# PLANNING AMENDMENT

Description: Erection of garage and summer house

Location: Linden House  
Church Gate  
Gedney

Amendment: Roof-lights added to garage  
Dwg.No.0208-02 & details of Roof-light

| Scale | 1:50     | Drawing No. | 0208-02 |

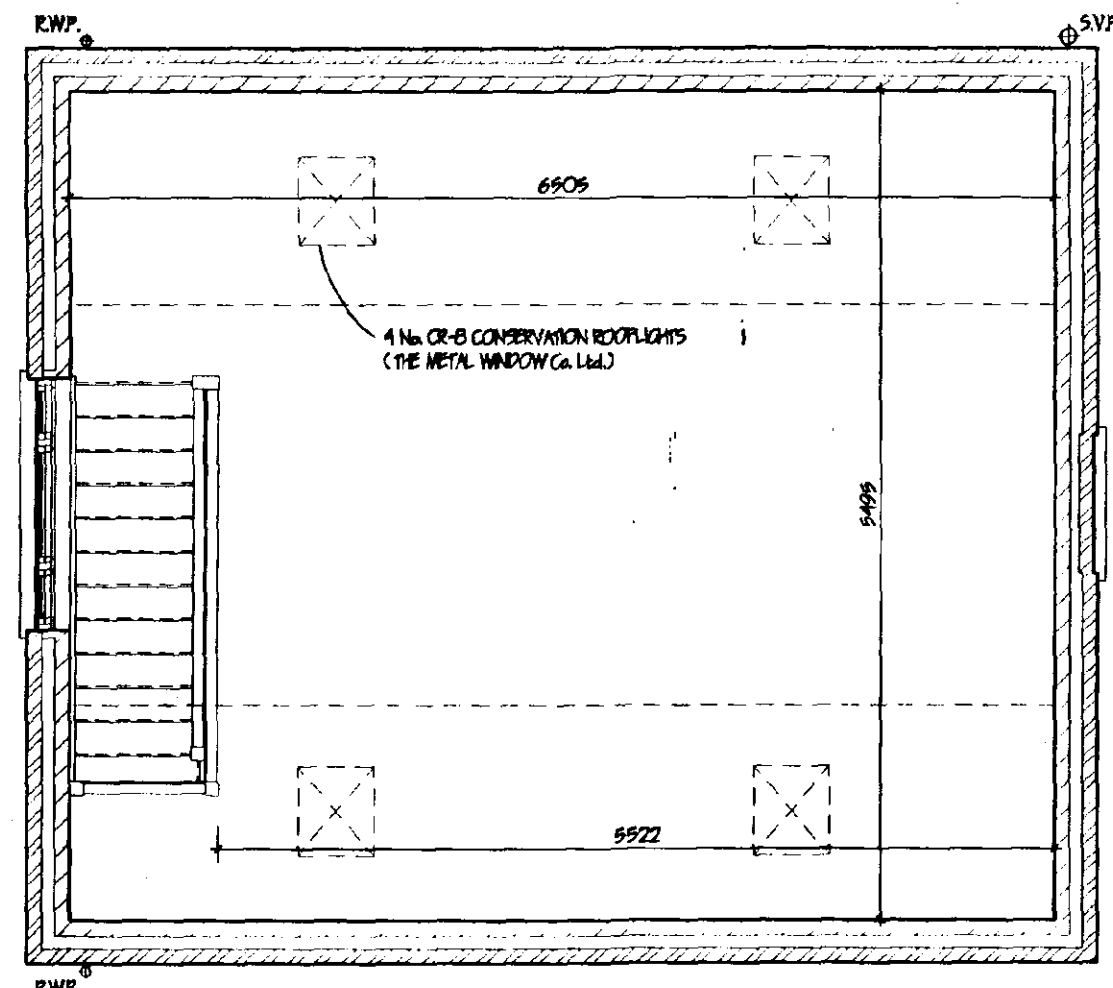
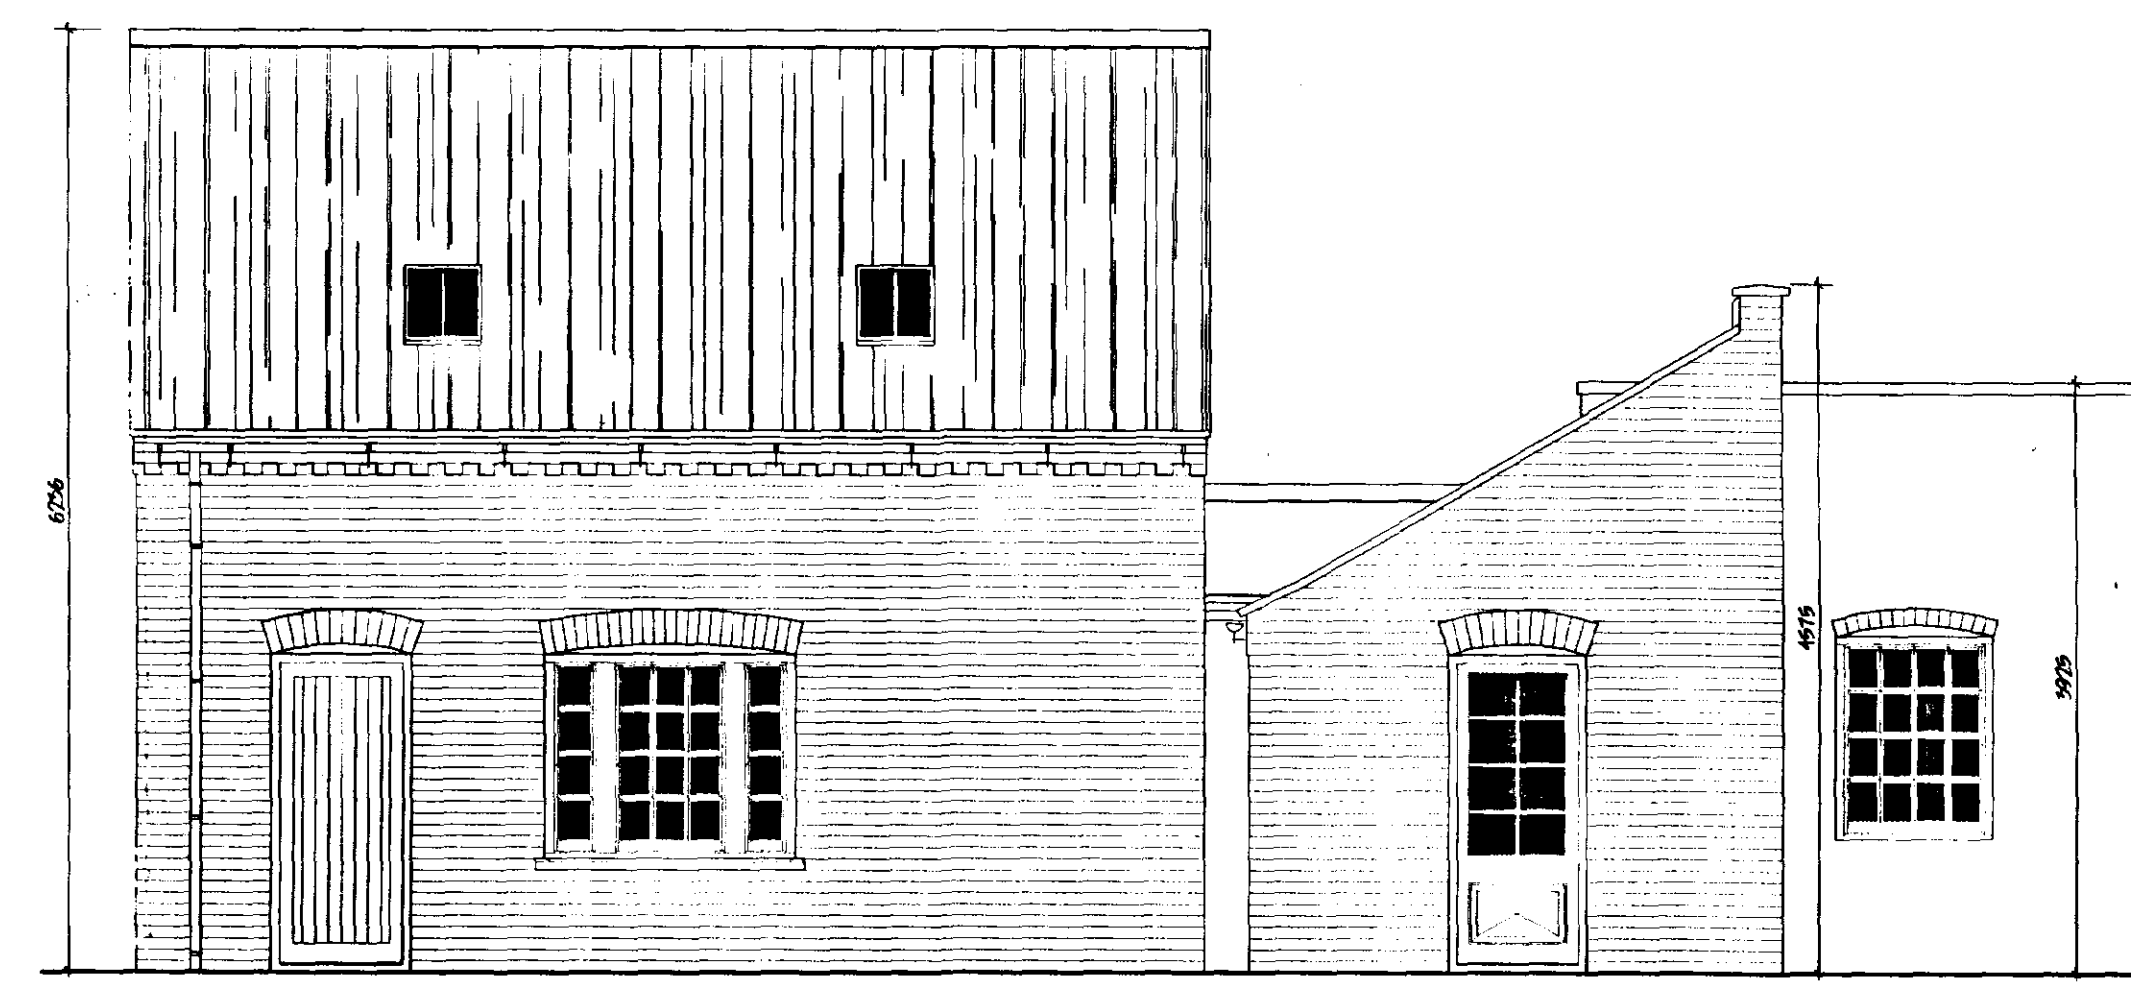
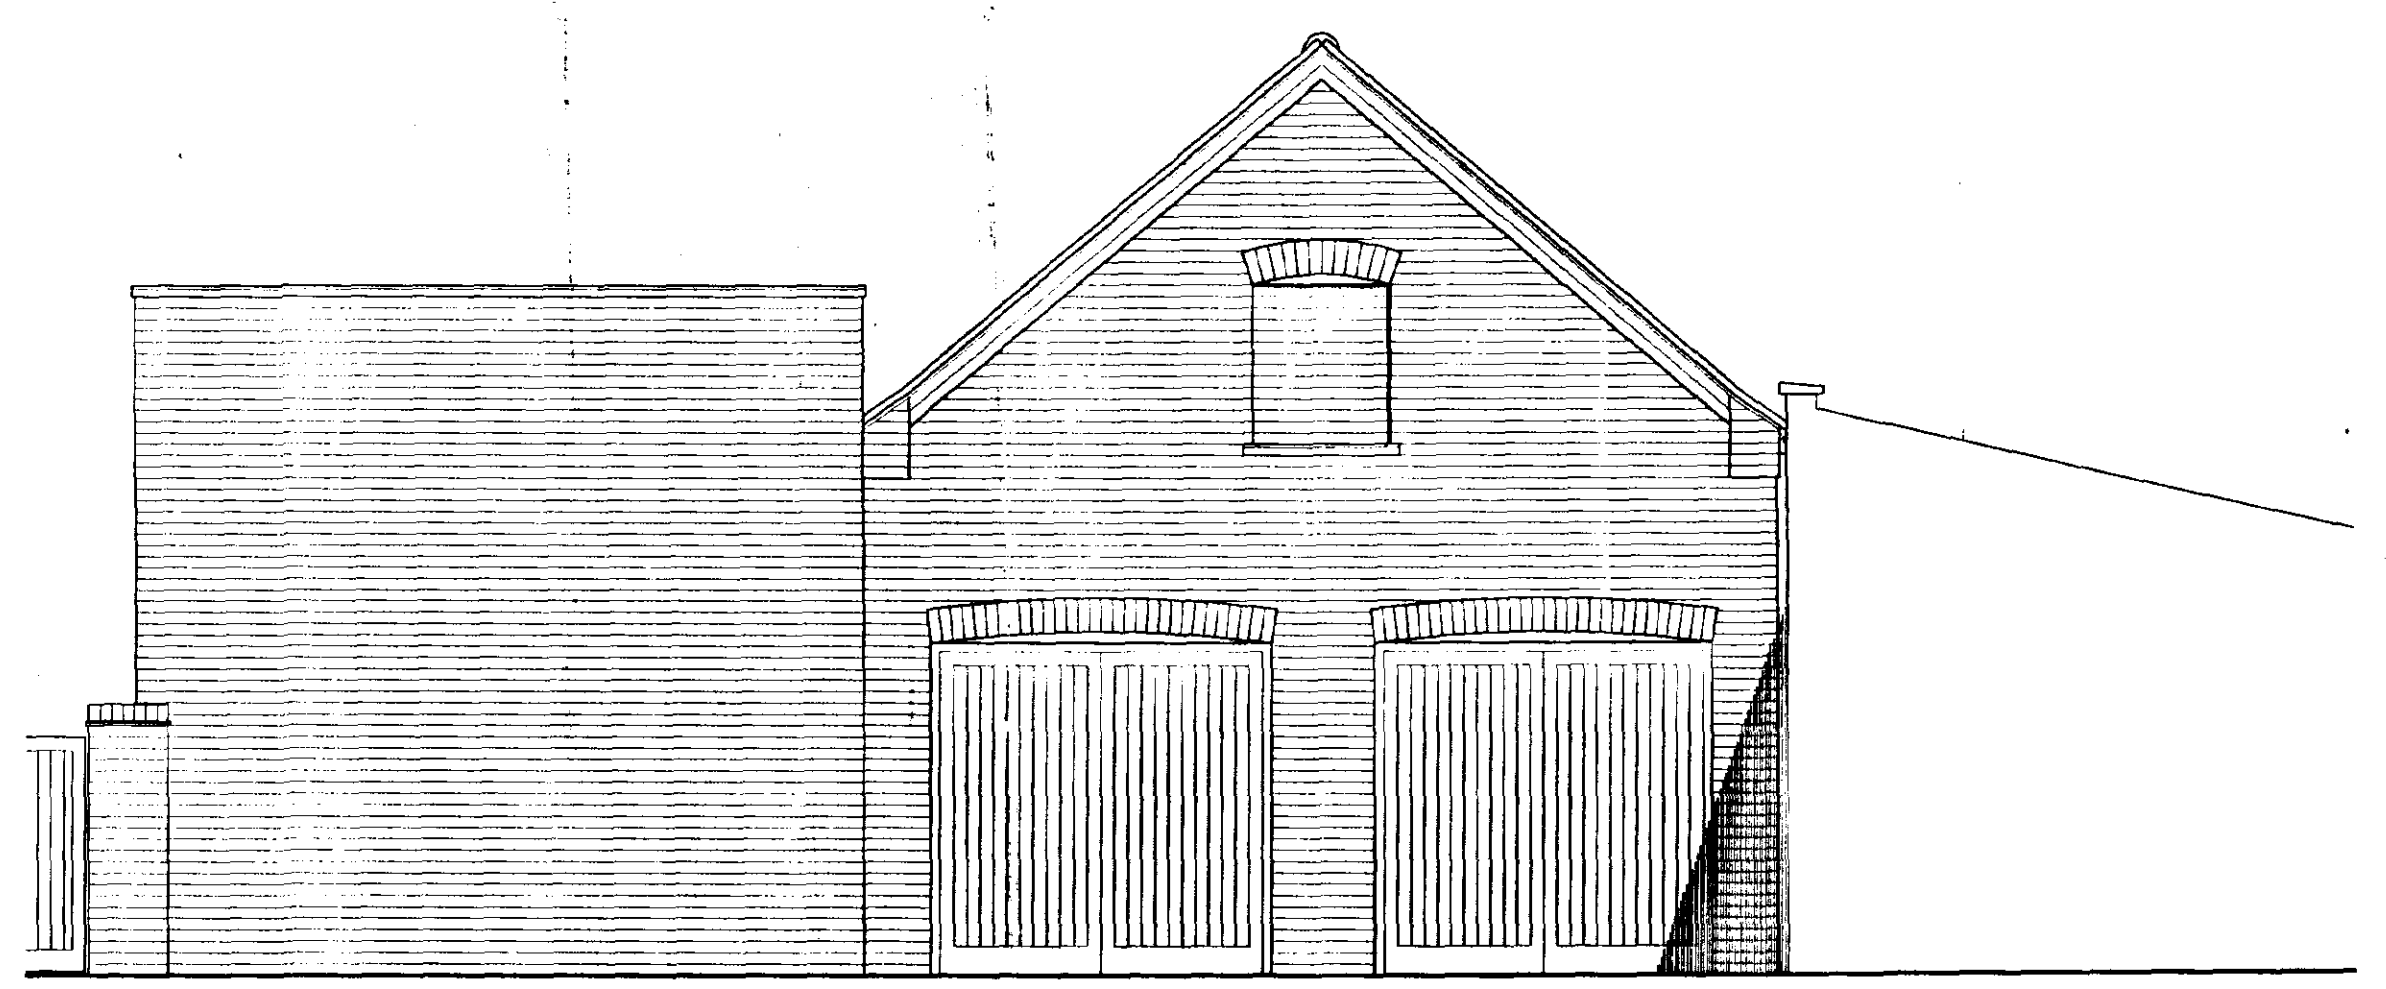
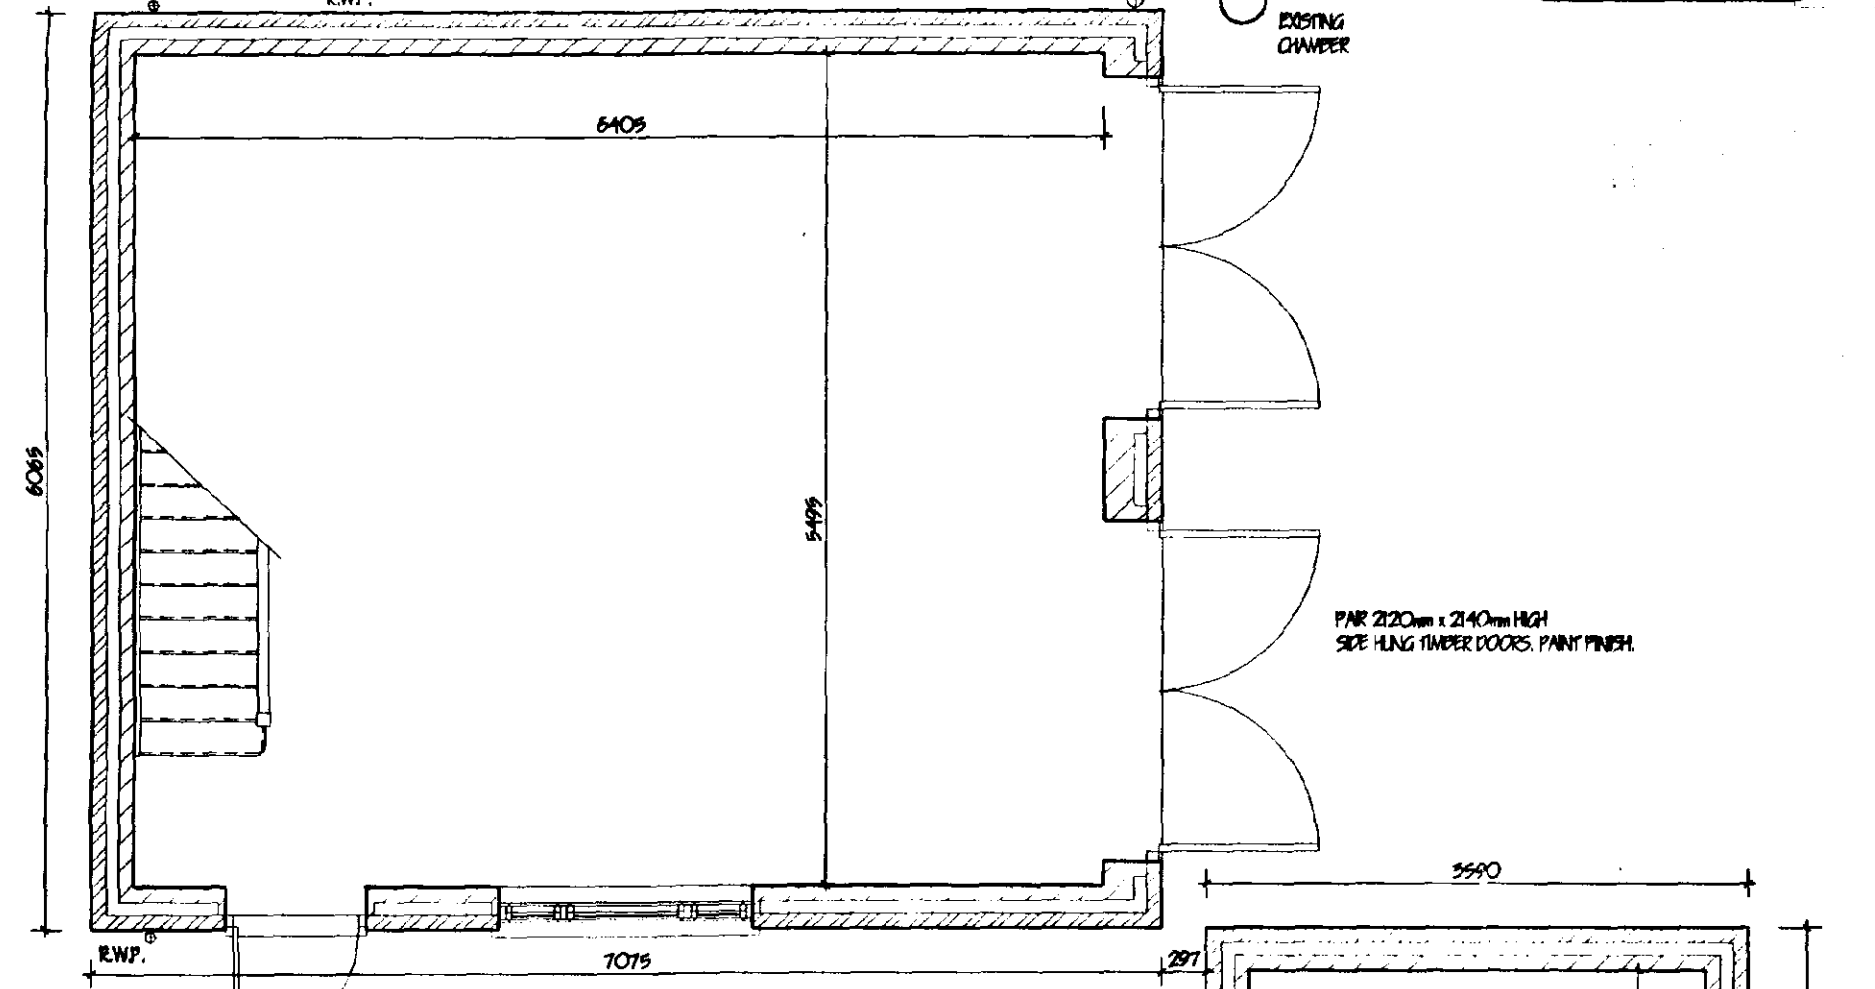
ROOF LIGHTS ADDED TO GARAGE
